Helton Mini Storage, PPR-18-019

Please accept the following comments from El Paso County Public Health for the 7.6 acre, plot plan review referenced above:

SOUTH ACADEMY BUSINESS CENTER

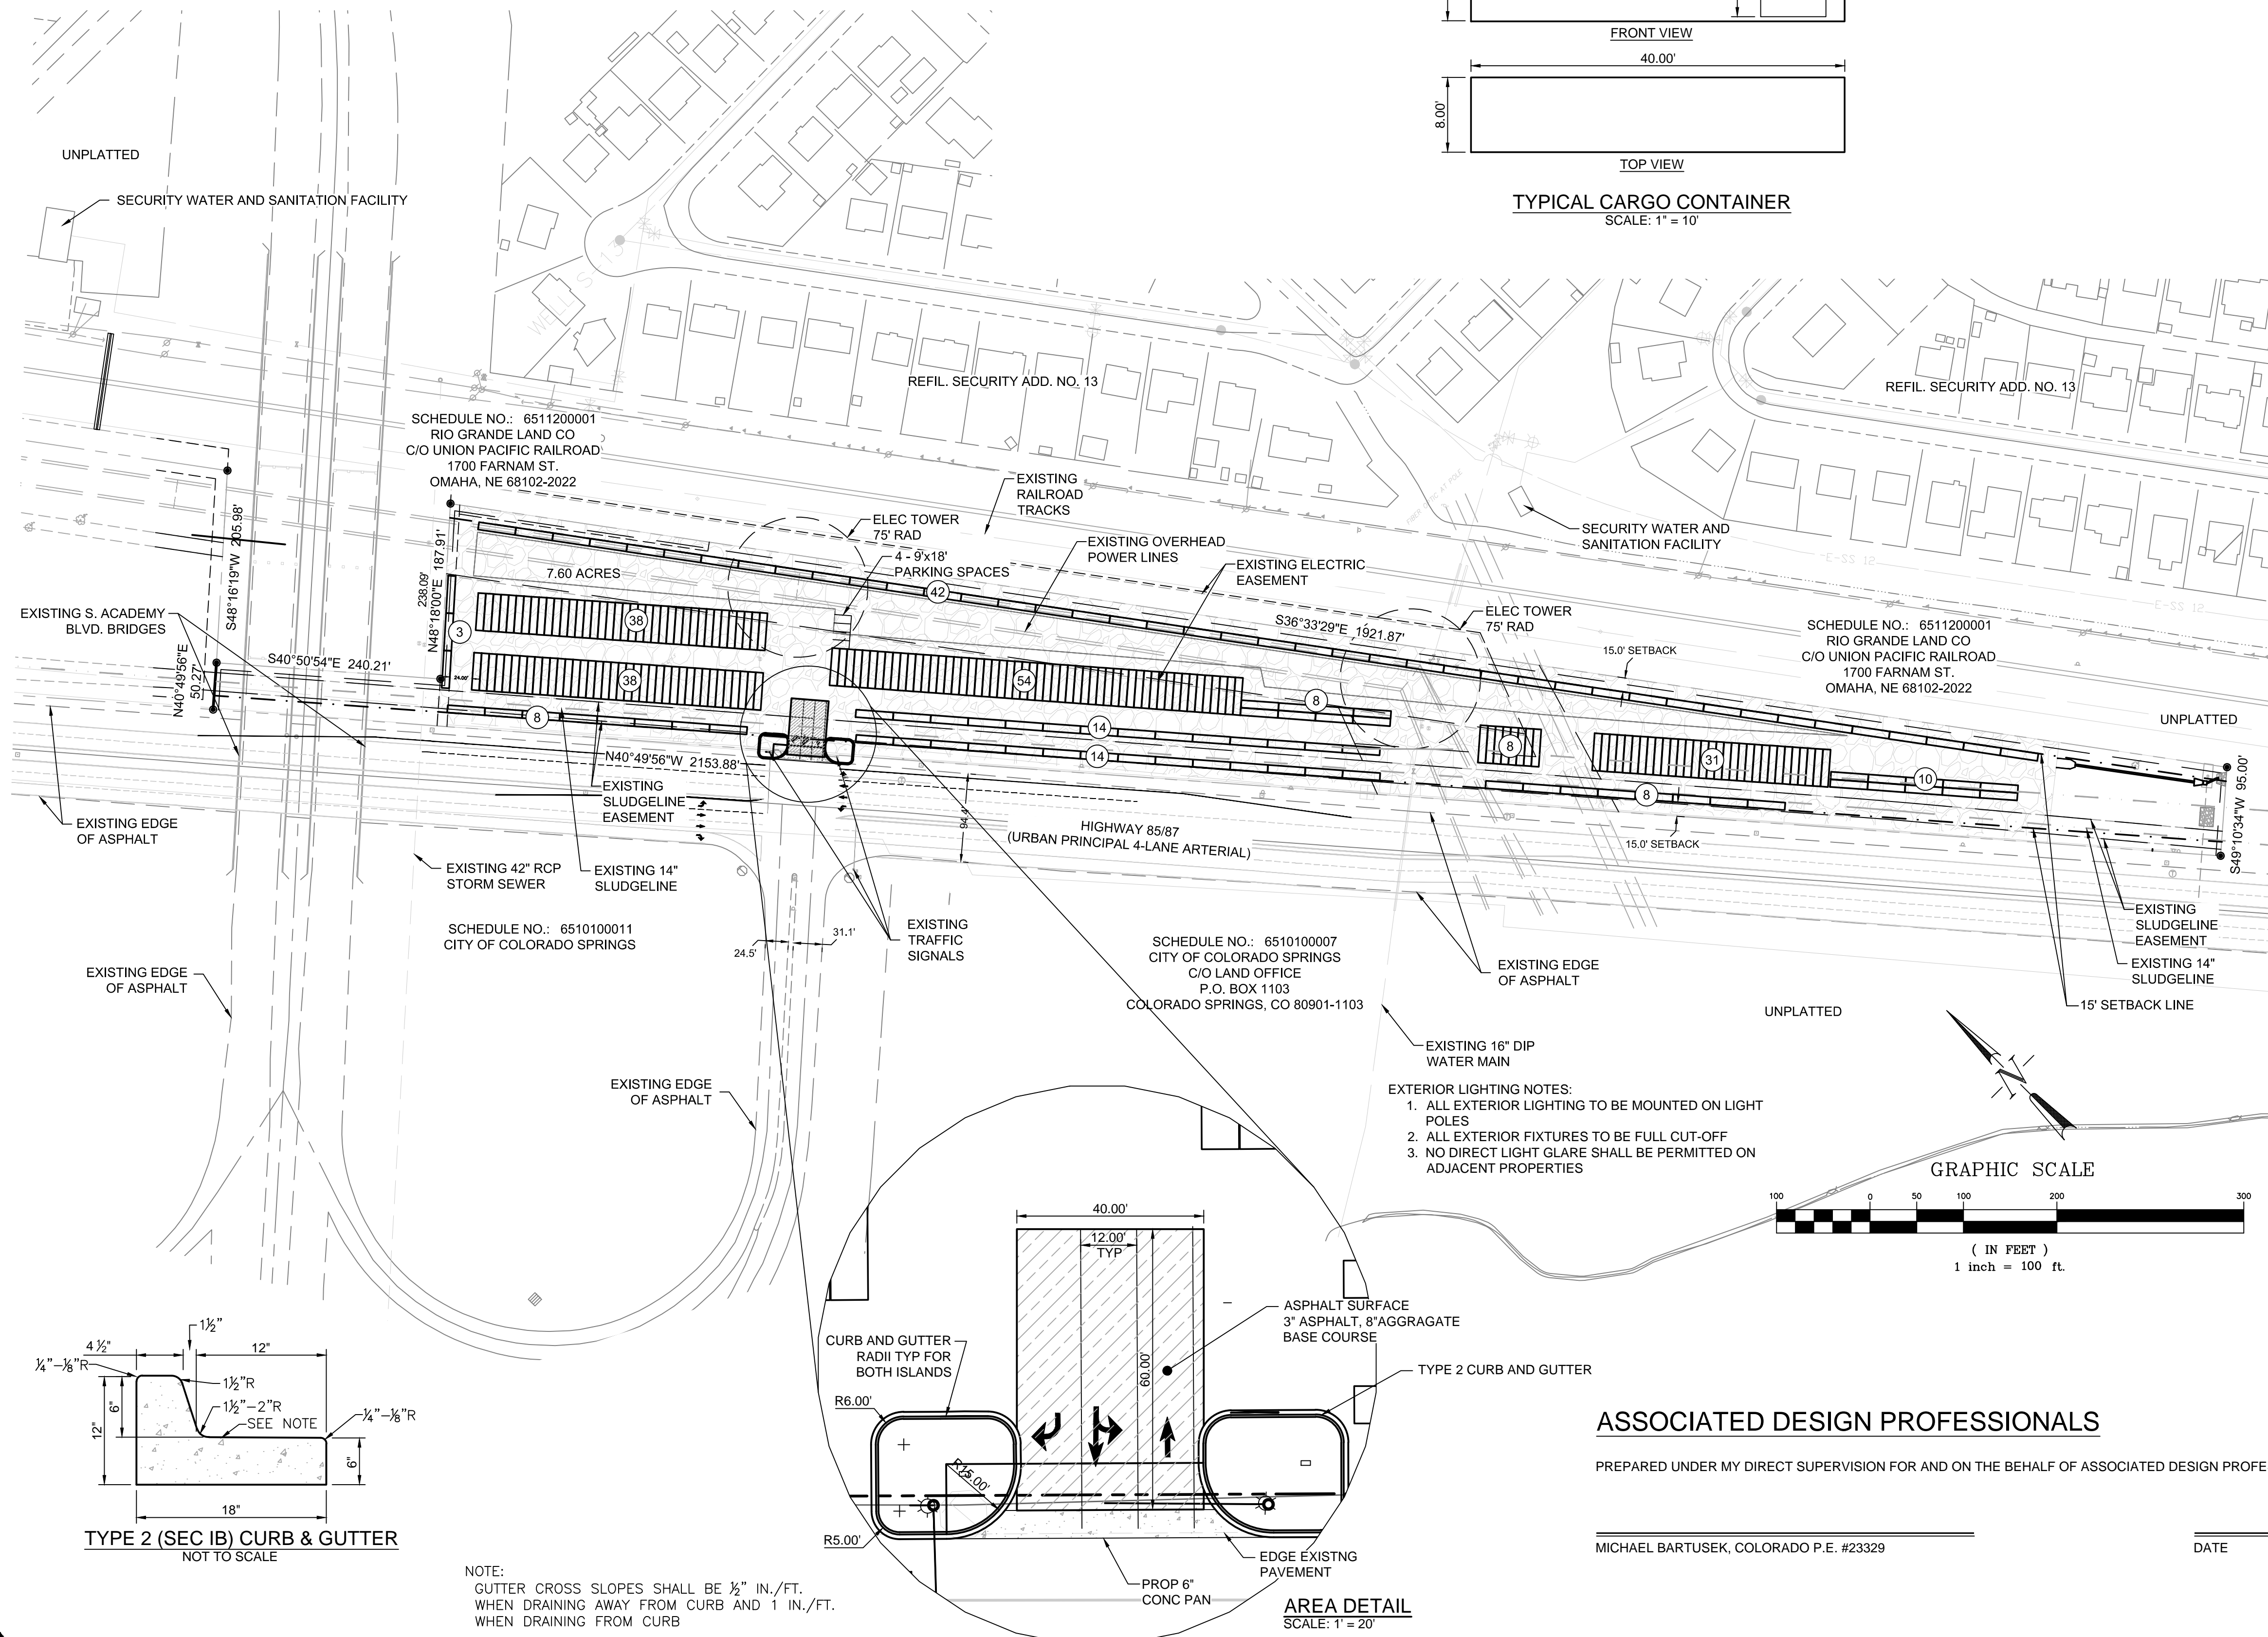
- Water and wastewater services are not proposed for this temporary mini storage facility. The property is planned to be developed as a “dry lot” and water for the office is proposed to be provided by bottled water. A portable chemical toilet is proposed for use during office business hours. Note: The office referenced in the Letter of Intent could not be located on the site development plan.
